TfNSW reference: WST23/00182/01 | SF2023/217600

**SSD-52786213 – Calala Battery Energy Storage System (BESS) – LOT 17 DP629969 – 57
Burgess Lane CALALA**

Transport for NSW (TfNSW) is responding to the SSD-52786213 referred on 14 November 2023.

TfNSW has reviewed the information and has **no objections** to the proposed development. Comments are set out in **Attachment 1** to assist the Consent Authority in assessing the development application.

APPENDIX 4: ROAD UPGRADES AND SITE ACCESS

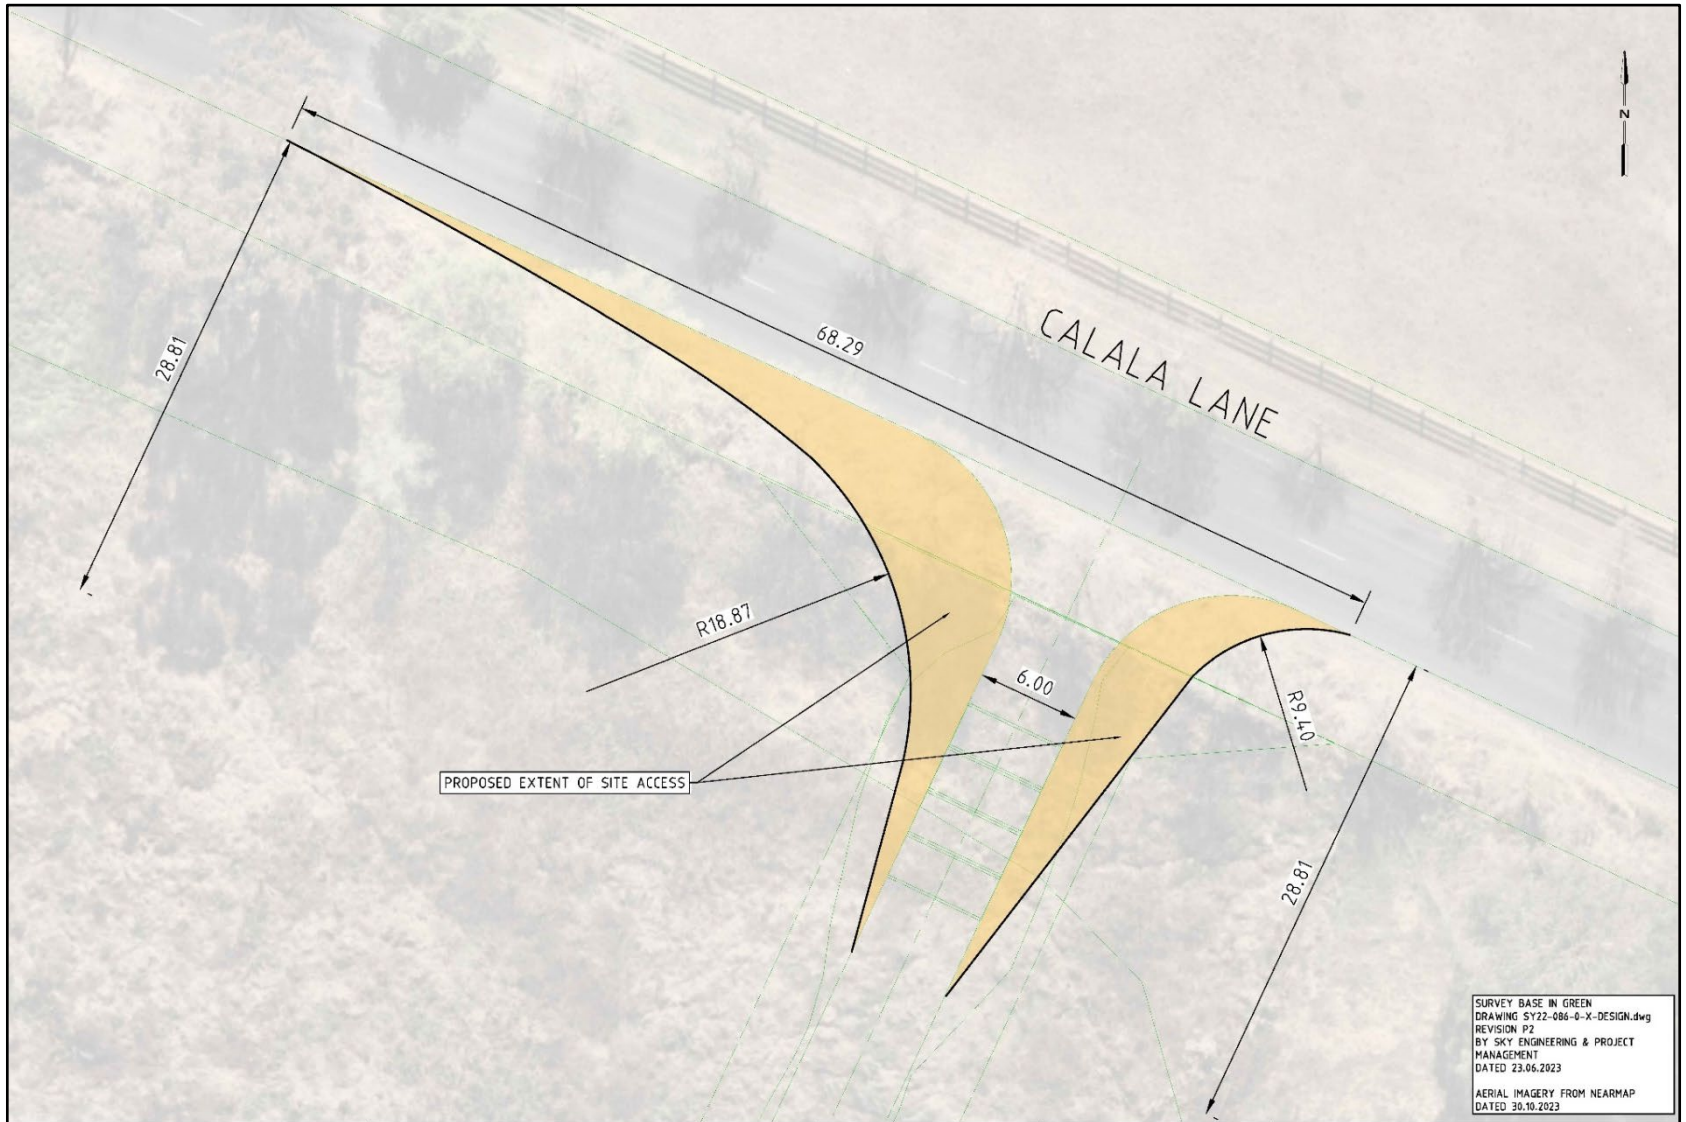
1. The TIA identifies that the final details on the proposed OSOM movements will be provided in the Traffic Management Plan (TMP). If road infrastructure such as medians, road widening or any other road upgrades are required to the classified road network which are identified Post-Consent within the TMP, then a modification will be required to obtain development consent for the additional scope of work required for the OSOM road infrastructure upgrades. TfNSW advises the review of the road infrastructure upgrades required for the OSOM movements occurs as a part of the EIS to avoid the requirement for a modification.
2. In relation to Point 1, the Bell Street overbridge and medians will potentially be impacted and will need to be reviewed to ensure that the structures are able to accommodate the OSOM vehicle movements for the Calala BESS.
